Application for a non-material amendment following a grant of planning permission.

Number	105
Suffix	
Property name	
Address line 1	Golden Avenue
Address line 2	
Address line 3	
Town/city	East Preston
Postcode	BN16 1QT
Description of site location must be completed if postcode is not known:	
Easting (x)	507841
Northing (y)	101736
Description

Replacement of flat roof dormer roofs with pitched roofs. Front extension and new flat roof to garage

Reference number:	K/26/19/HH
Date of decision	25/11/2019

Drawing P01a September 2019 Scale 1:100 @ A3
Planning Drawing - Ground Floor Plan and Elevations

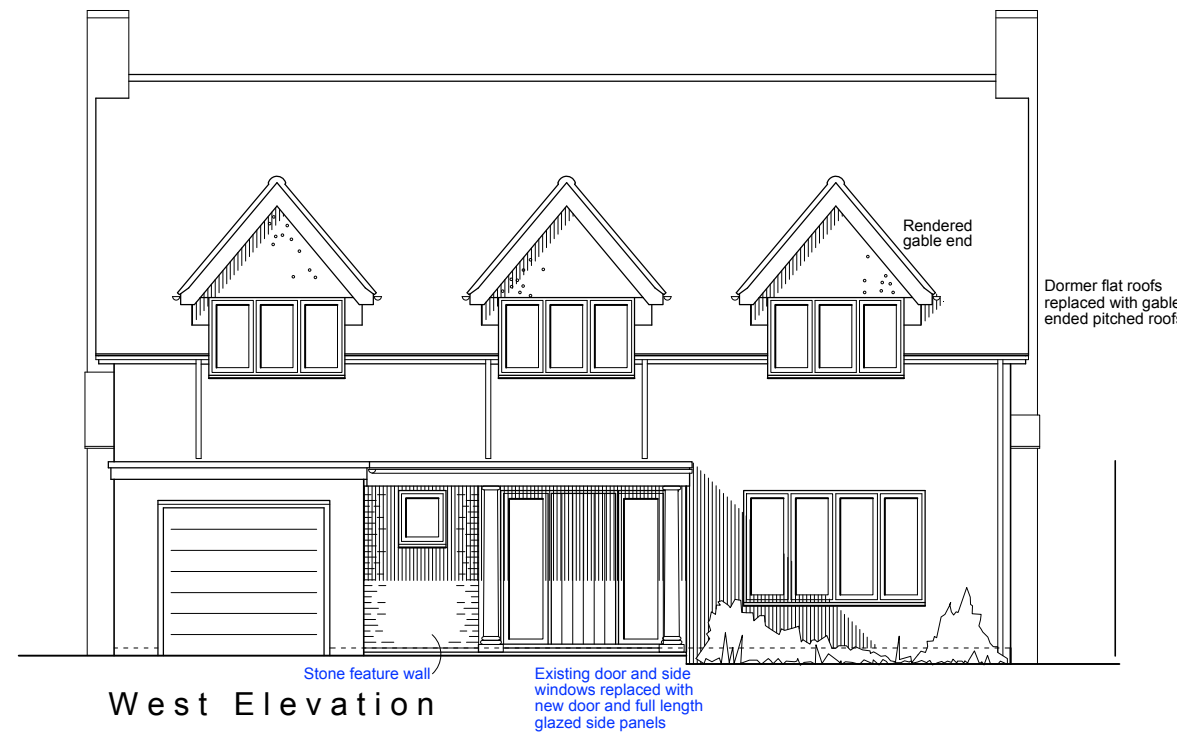
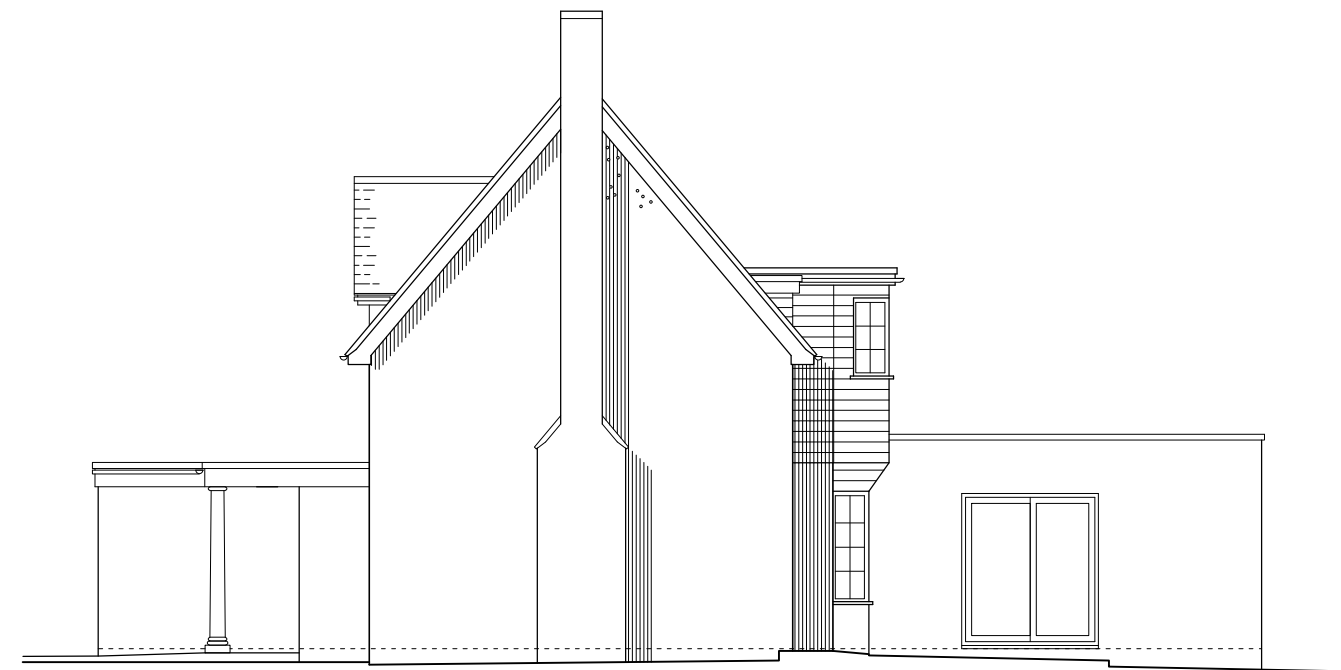
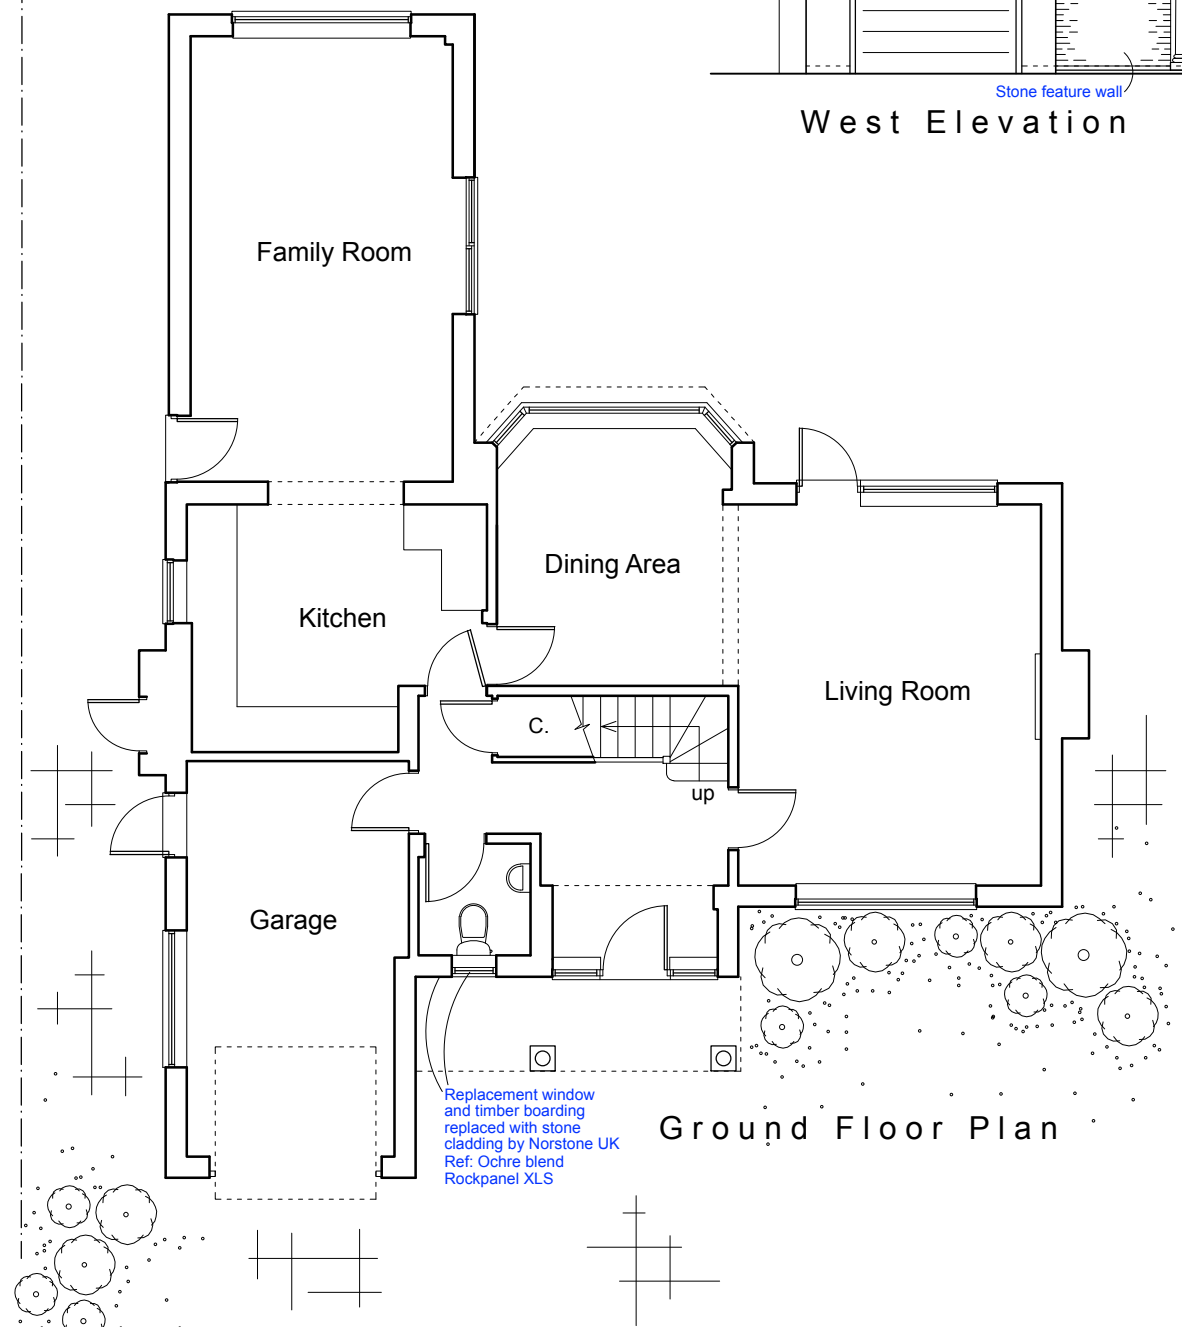
Removal of ground floor extension; stone cladding to existing porch wall

Drawing P01a and P02a
